Addendum No. 2

RE: Contract # C204108

Johnston County (R-3825B)

NC-42 From East of SR-1902 (Glen Lural Road)

UTILITY CONSTRUCTION

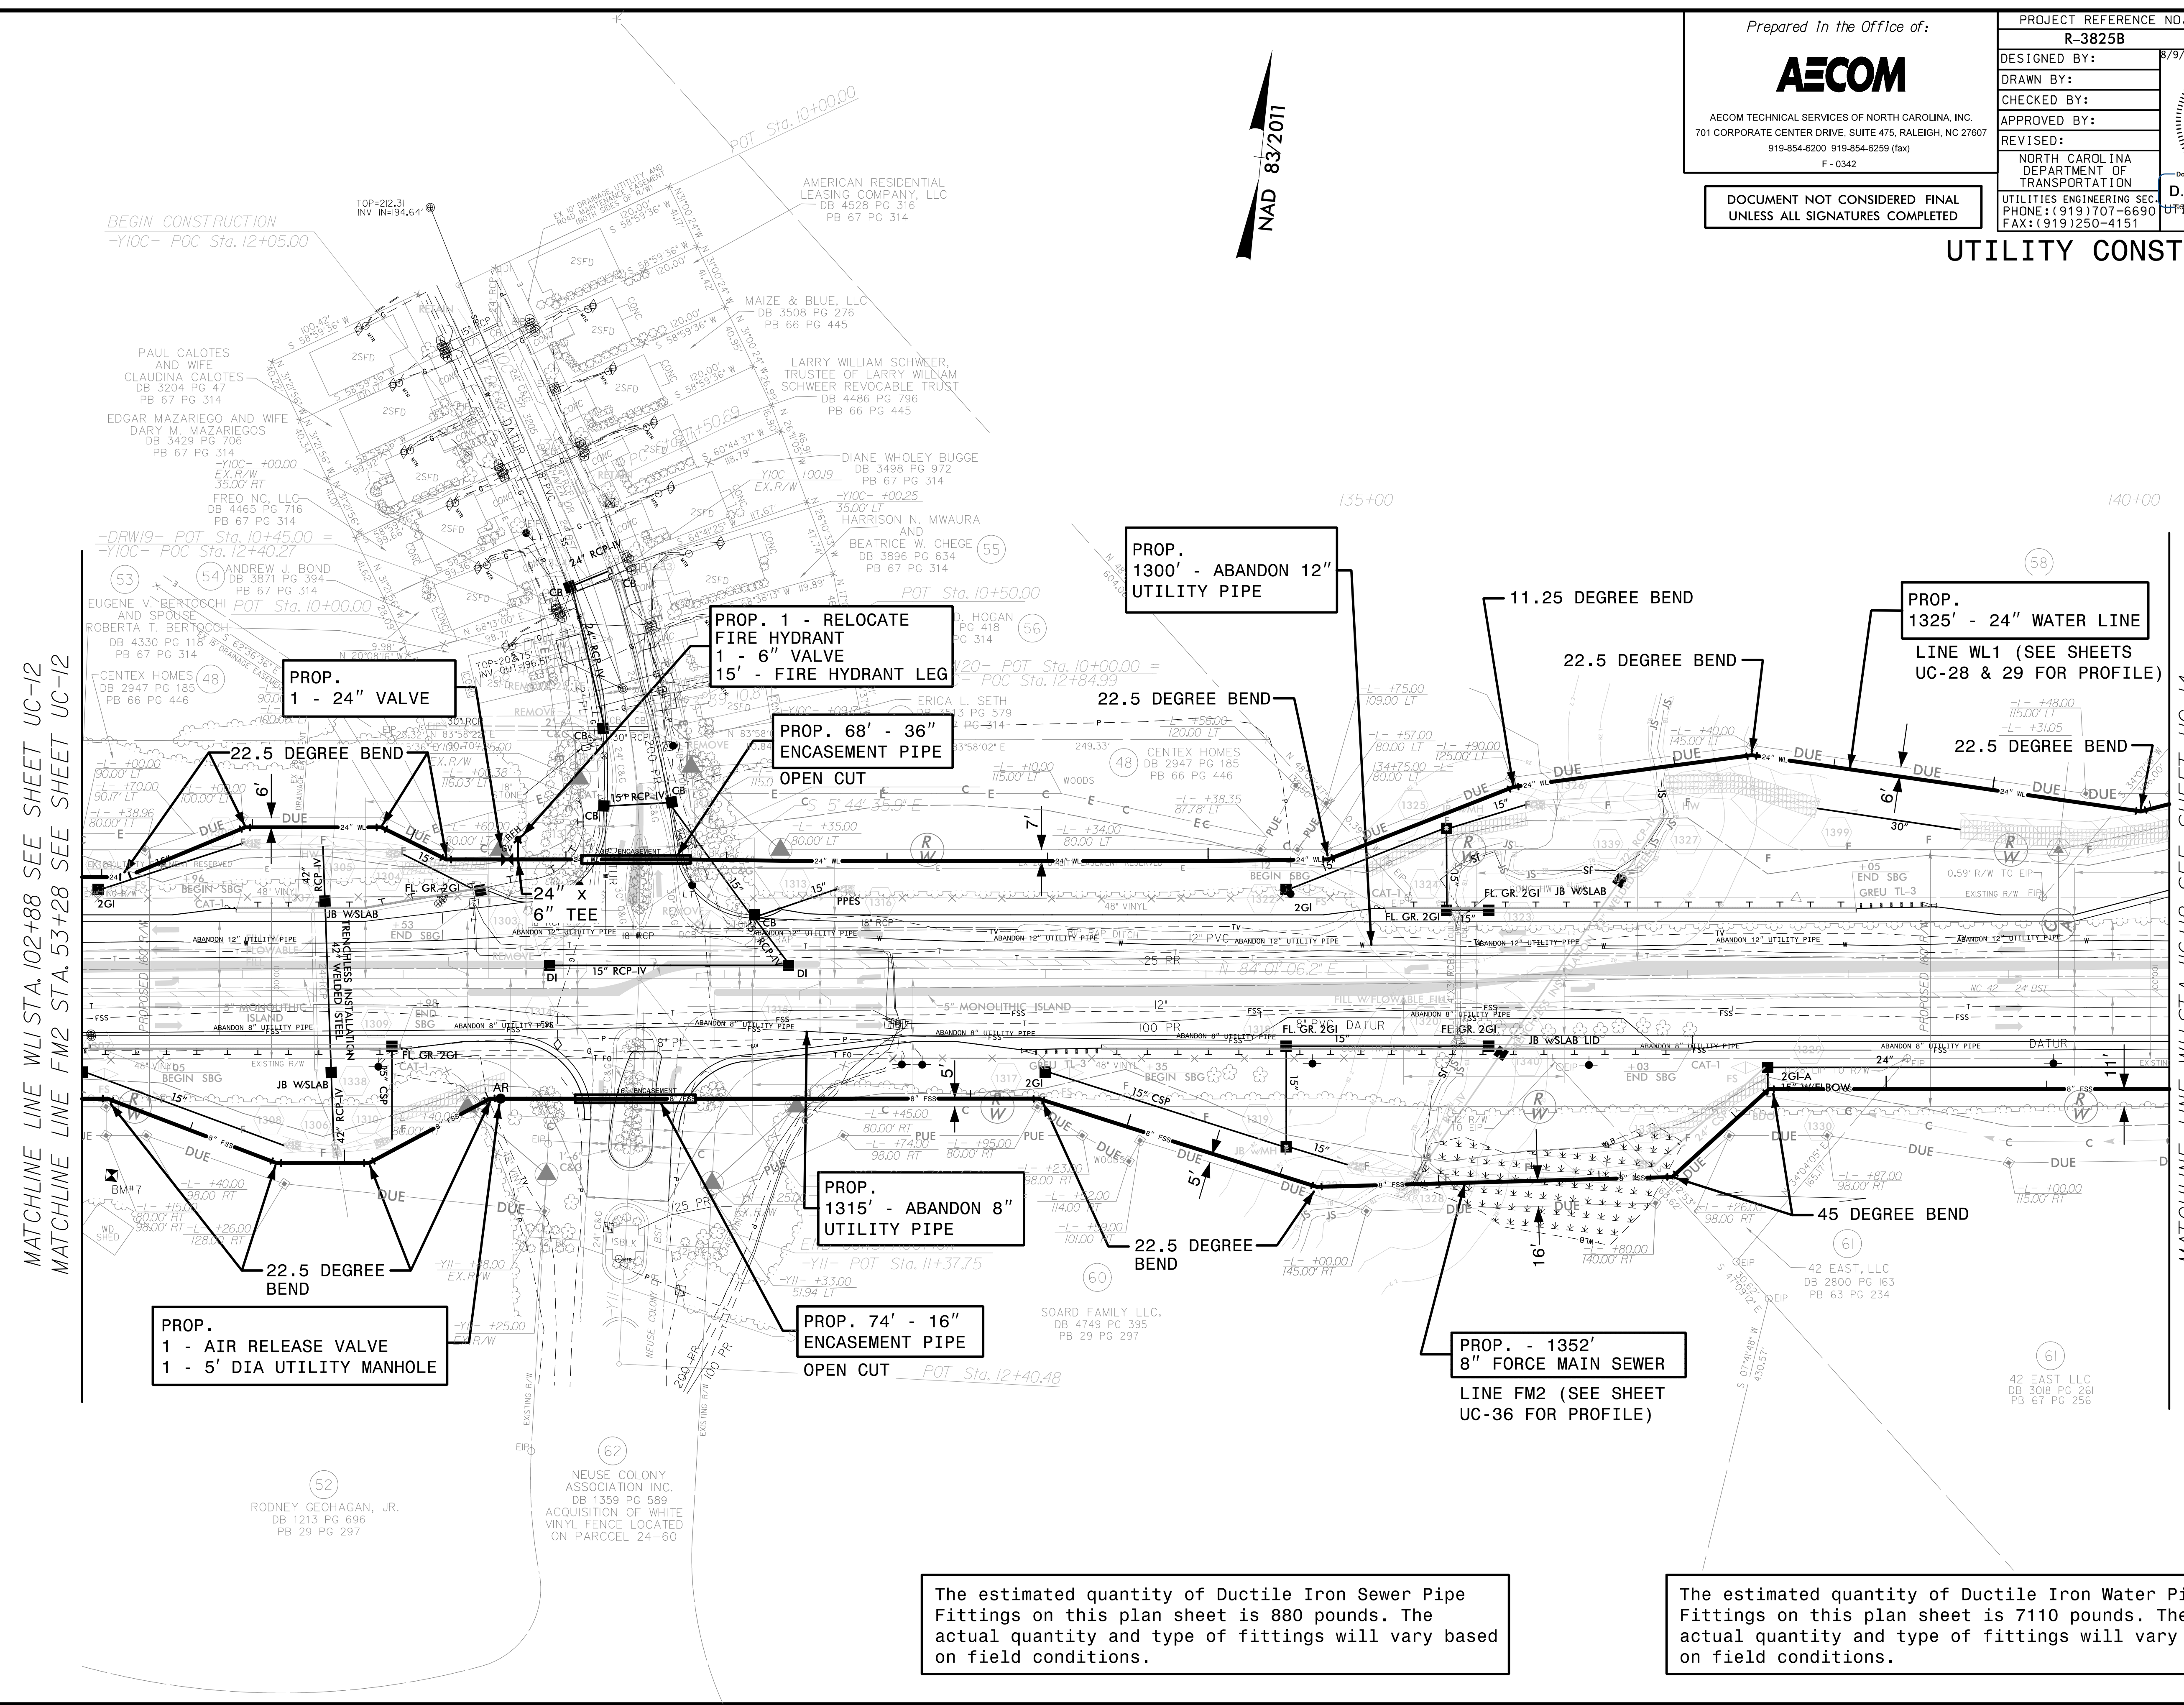
Sheet No.	Revisions
EC-12A	Revised notes concerning shoring in the culvert phasing
UC-4, UC-6, UC-7, UC-9, UC-10, UC-12, UC-14, UC-15, UC-19, UC-20 and UC-22	Revised to add "Remove Fire Hydrant"
